**KIRKLEES METROPOLITAN COUNCIL
INVESTMENT & REGENERATION SERVICE**

**DELEGATED DECISION TO DETERMINE APPLICATIONS FOR
NON-MATERIAL AMENDMENTS**

Reference No: 2025/NM/93370/W

Description: Non material amendment to previous permission
2021/92062 for erection of 9 dwellings and associated
works

01 BOUNDARY WALL (FRONT) - PART ELEVATION & DETAIL SCALE 1:20

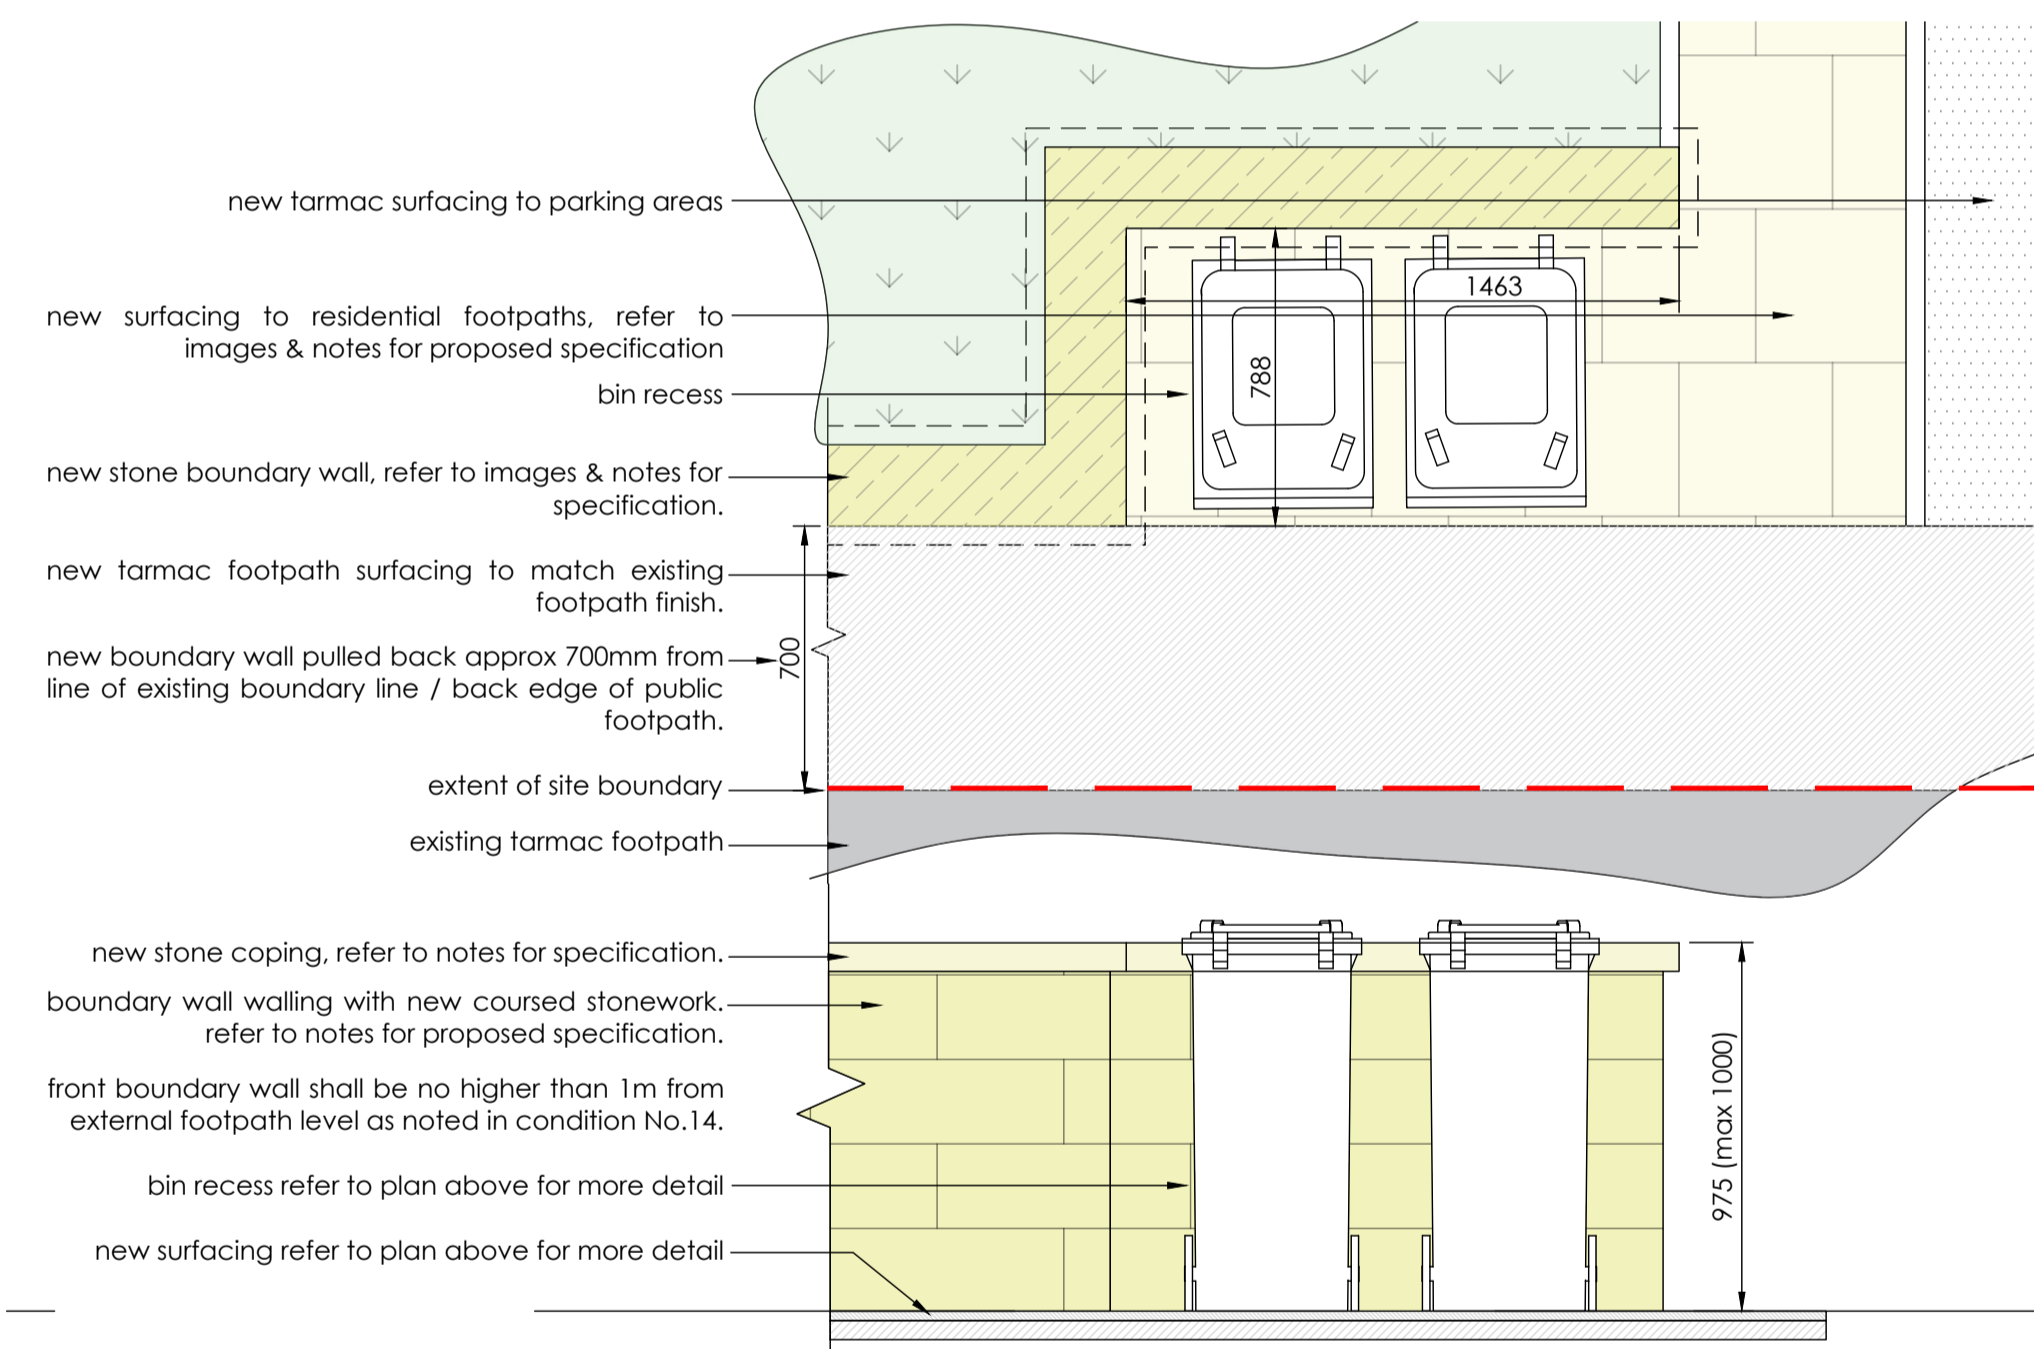
- Modifications to the previously approved retaining and boundary walls to accurately reflect the correct site levels.
- Revision of boundary walling agreed under AIP approval.

Plans have also been submitted which show details of boundary treatments. These details are required to be discharged under Condition 14 of previous planning permission 2021/92062.

14. Boundary treatment and treatment of retaining walls (i.e. facing materials) throughout the site shall be undertaken in accordance with hereby approved drawing nos. 100, Rev B, 101, Rev B and 102 Rev C, received 08/12/2025. The front boundary wall, adjacent to Britannia Road, shall not exceed 1.0m in height. The dwellings shall not be occupied until the works comprising the approved scheme have been completed and thereafter retained for the lifetime of the development.

ISSUED FOR:		PLANNING	
Project/Client:	Residential Development	Project No:	23-035
Land at Britannia Road	Golcar, HD3 4QB	Dwg No:	100
Scale:	A.S.	Rev:	B
Drawing:	Proposed Site Plan & Boundary Elevations	Scale:	@A1
Drawn By:	RJ	Date:	02/01/24
Checked By:	SC	Date:

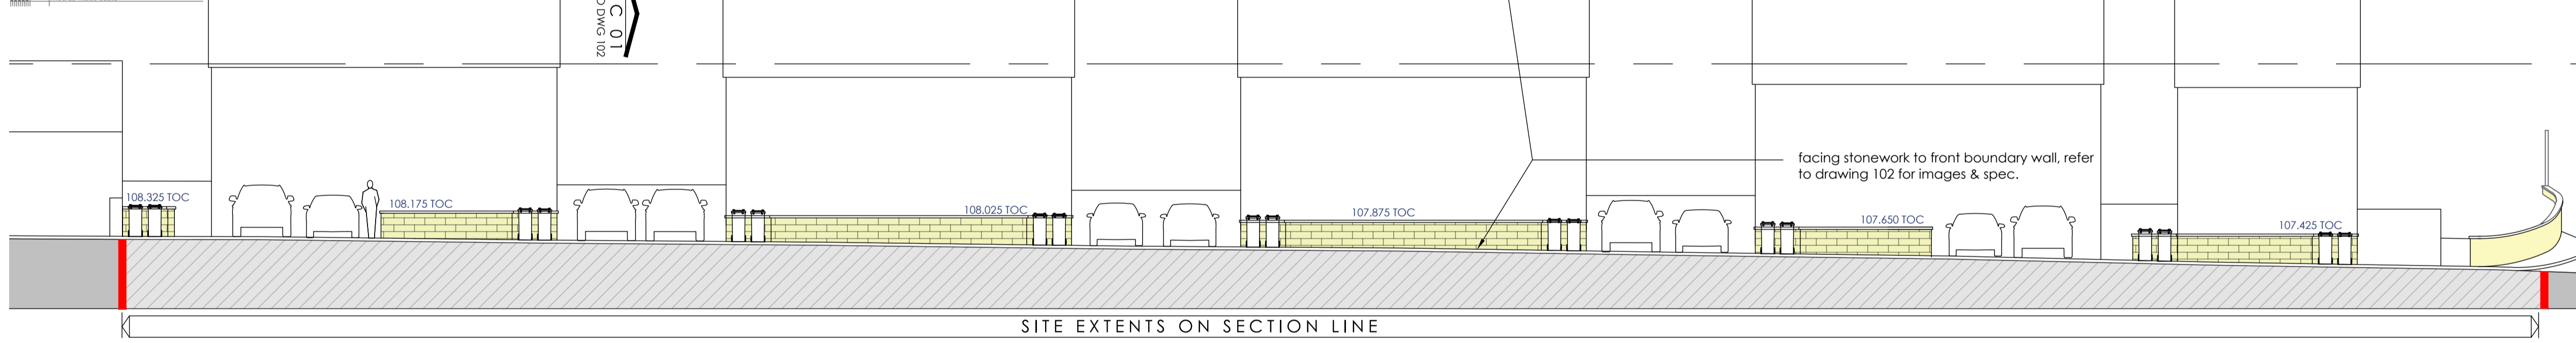
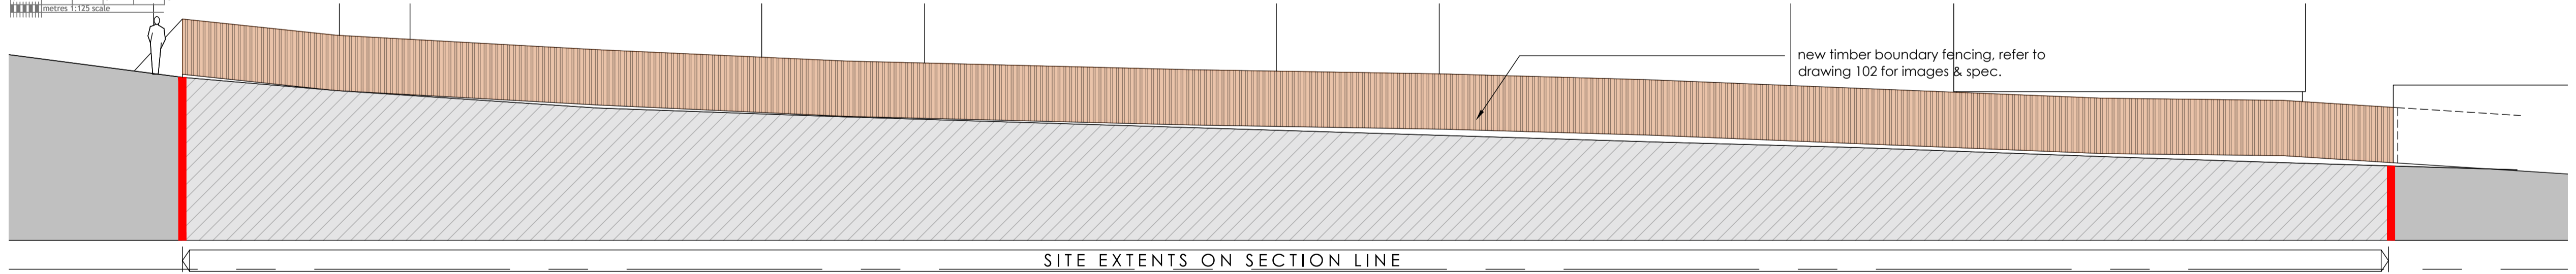
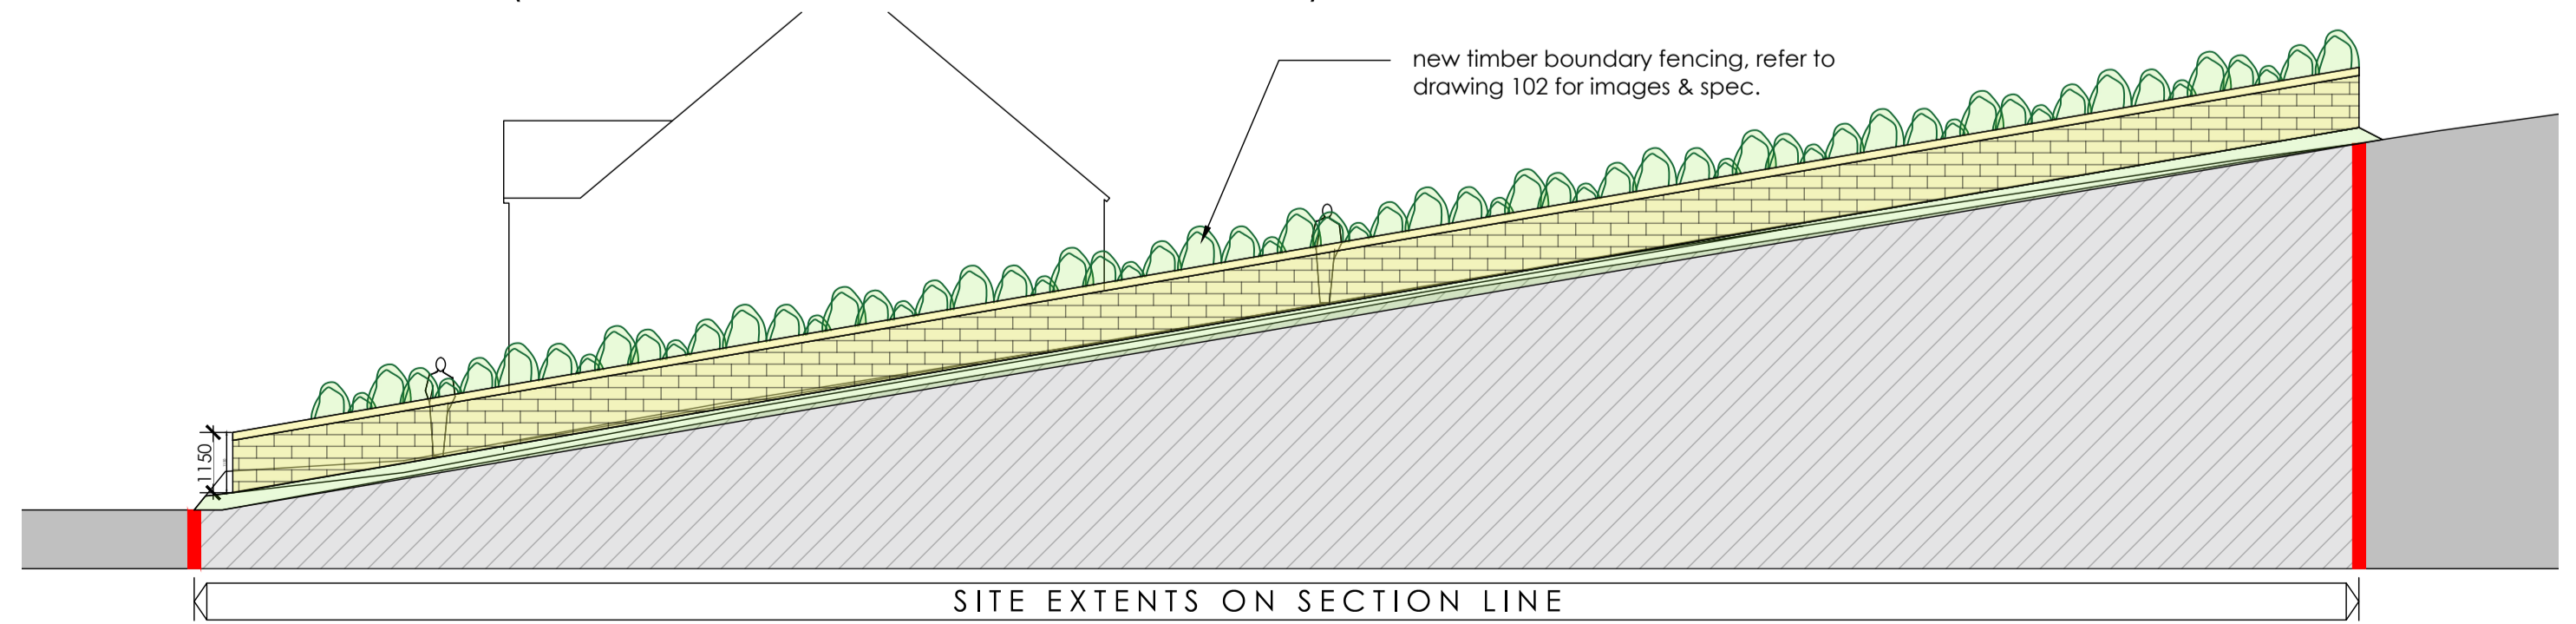
Amendments have been sought to replace the majority of originally approved retaining walls with batters in the rear gardens of plots. A retaining wall is shown to be provided to the south of the main batter which runs along the northern boundary of the site.

NO. Changes to the levelling of the gardens to the rear of plots would not result in any increased overlooking/overbearing impacts, it would simply replace some of the retaining boundary treatments with batters. The boundary treatments proposed to the front and rear are also similar to those approved under the original application. Changes proposed to the side boundary treatments would not impact on any neighbouring properties amenity and would result in a more sturdy and less dominating boundary treatment along the eastern boundary of the site.
